# Rezoning Transportation Analysis

Petition Number: #2022-032

**From:** Jake Carpenter, PE

Date	Description
07-26-22	First Review (PDM)
08-23-22	Second Review (WB)
09-28-22	Third Review (JC)

**REZONING PETITION #2022-032**  
**SCHEMATIC SITE PLAN**

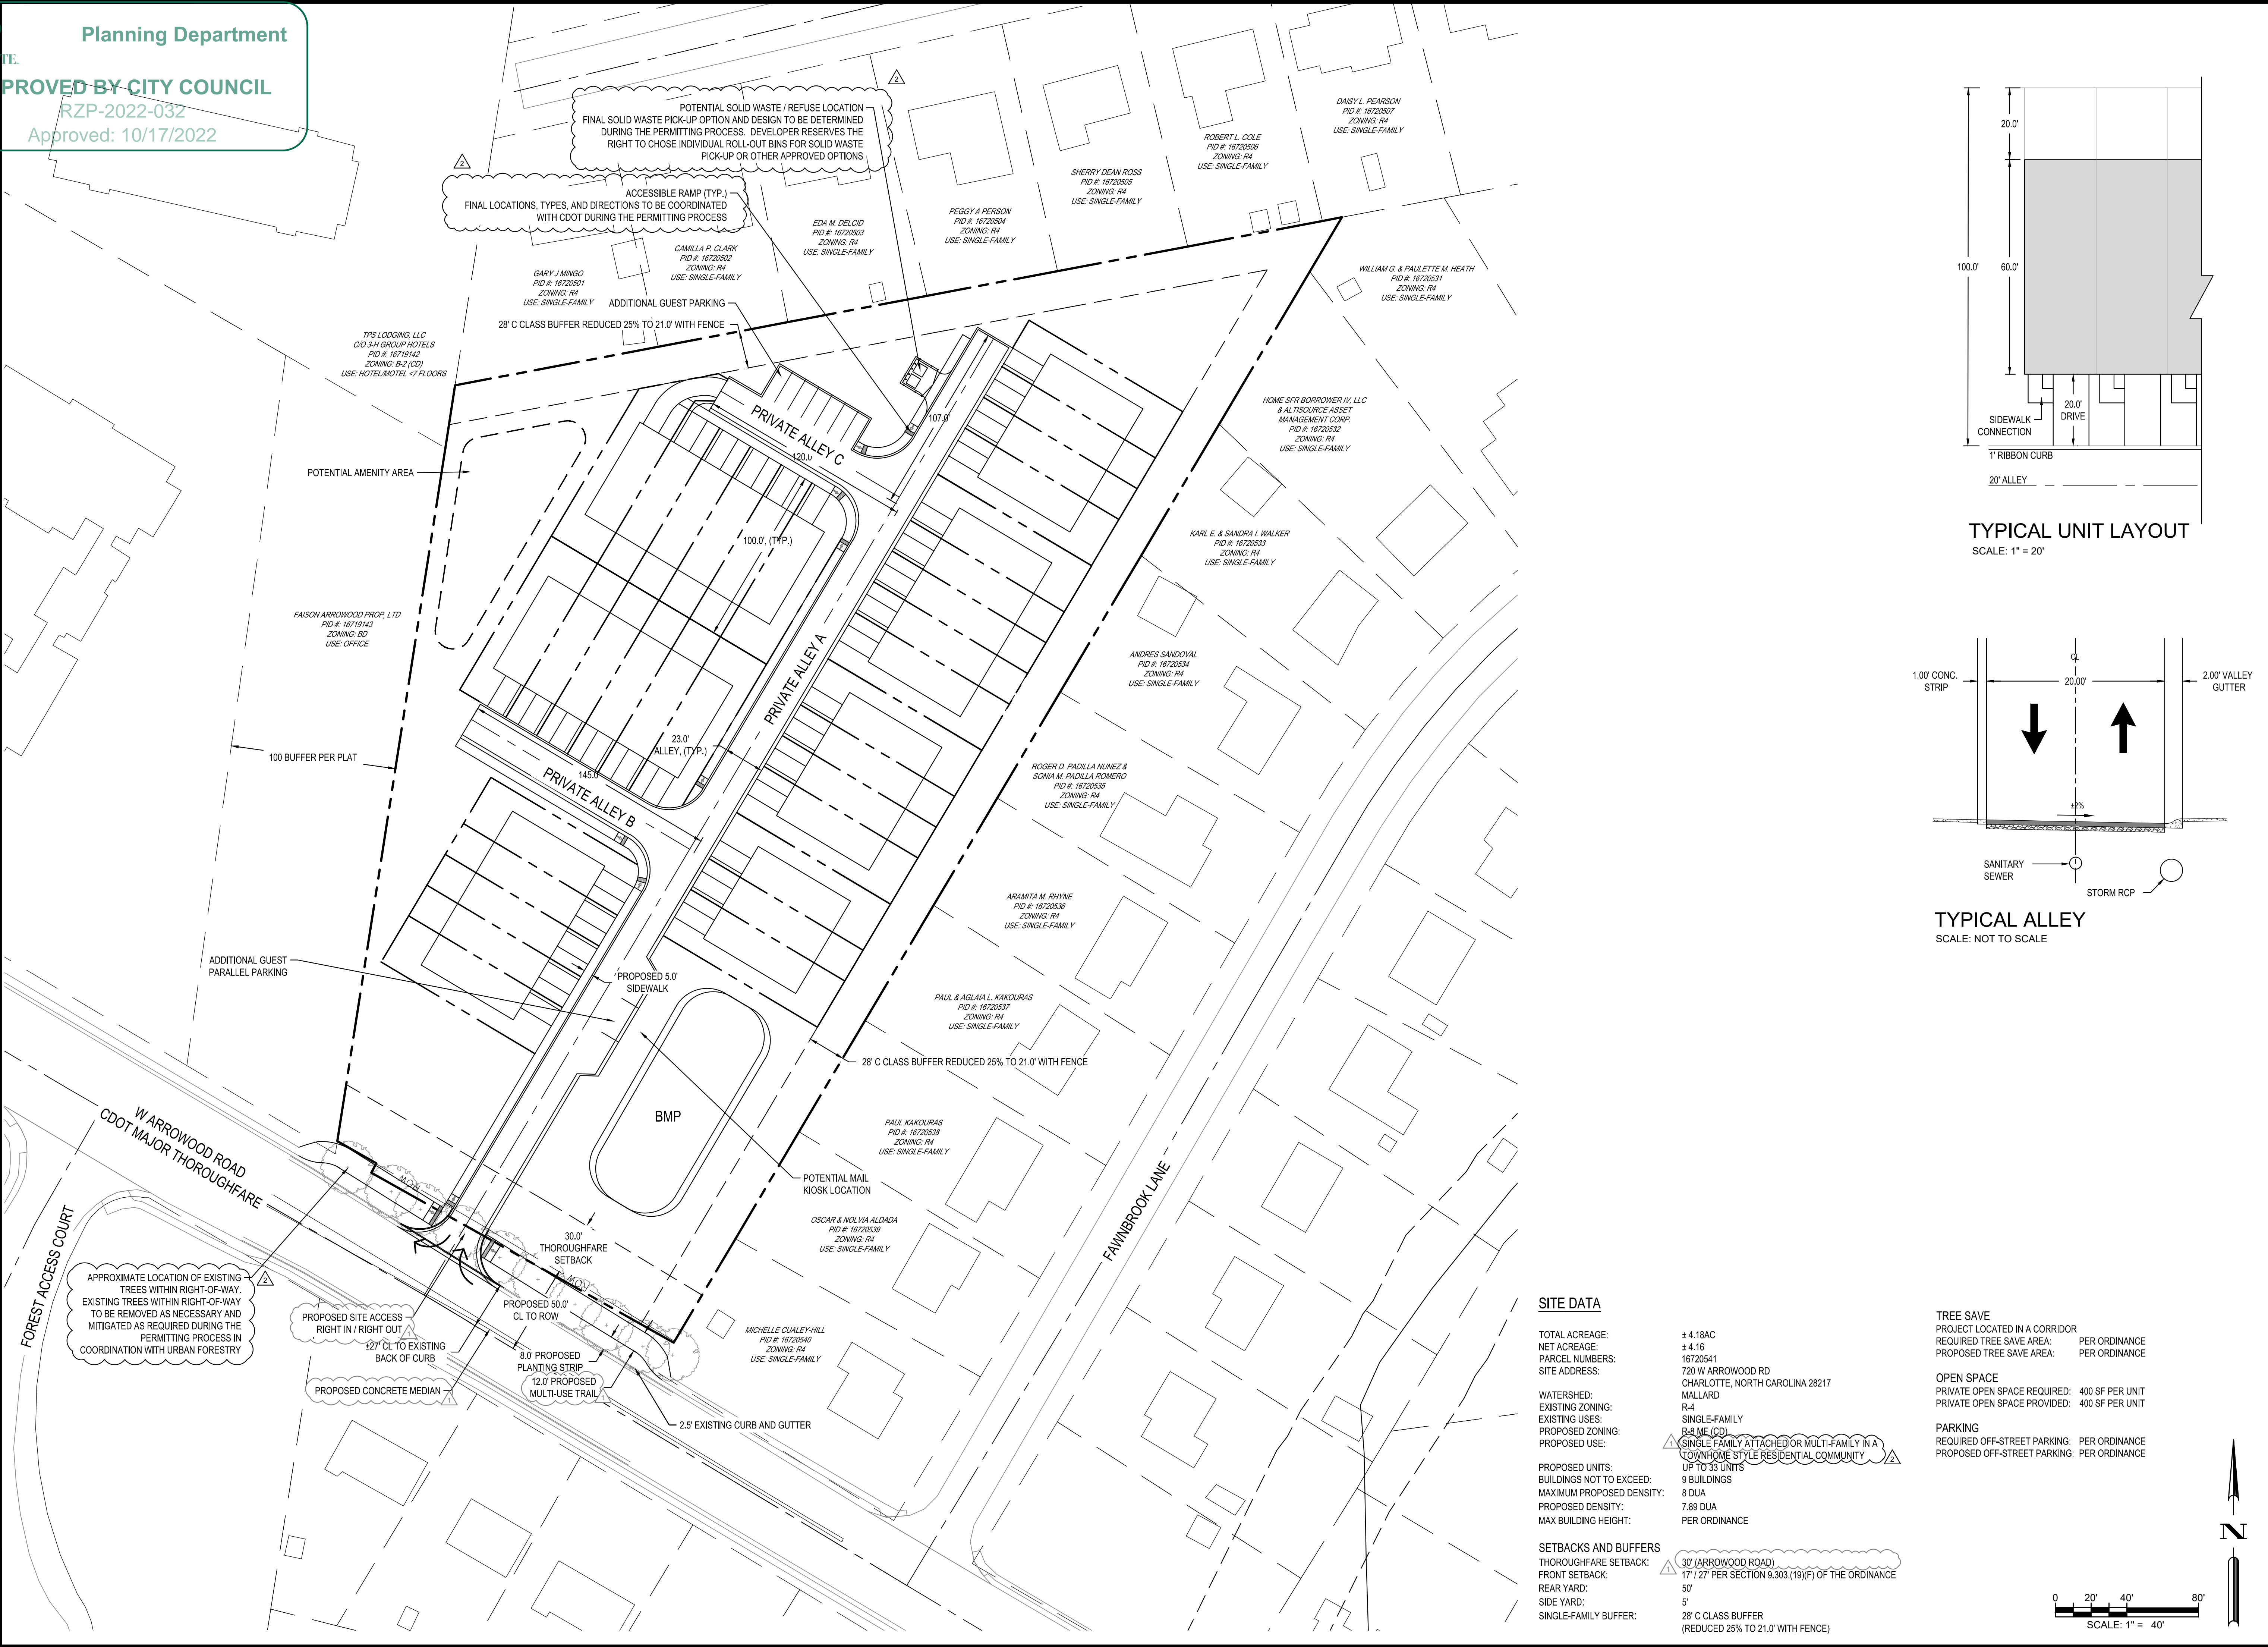
3. ~~Site plan and conditional note(s) revisions are needed to commit to installing a 12' multi-use path along Arrowood Road to meet the City Charlotte BIKES Policy.~~

4. ~~Revise site plan to dedicate 50 feet of right of way from the Arrowood Road centerline if it does not exist. The site plan shall label and dimension the right of way from the road centerline. Ensure a continuous 50ft ROW is provide at a minimum for the full length of the site.~~

6. ~~Site plan and conditional note(s) revisions are needed commit to installing a required Left Turn Lane into the site on Arrowood Road into the site. label and dimension left turn lane on site plan and add conditional note describing all turn lane design requirements. The existing left turn lane should be restriped to accommodate the new street. **Comment Rescinded (8/23/2022) – Access will be limited to a right-in and right-out condition.**~~

7. ~~Site plan and conditional note(s) revisions are needed to commit to extending the proposed sidewalk and ADA compliant sidewalk ramps closer to the intersection of Private Alley B.~~

- 8. **NEW Comment (Based on revised Site plan 8/23/2022)**  
Provide Accessible ramps at intersections per ADA law.

The petition is located adjacent to Arrowood Road, a city-maintained major thoroughfare and west of Fawnbrook Lane, a city-maintained minor collector. A Traffic Impact Study (TIS) is not needed for this site. The petitioner has coordinated with CDOT to provide a 8' planting strip and 12' multi-use path along Arrowood Road per Charlotte WALKS and Charlotte BIKES council-adopted policies. CDOT has no outstanding issues.
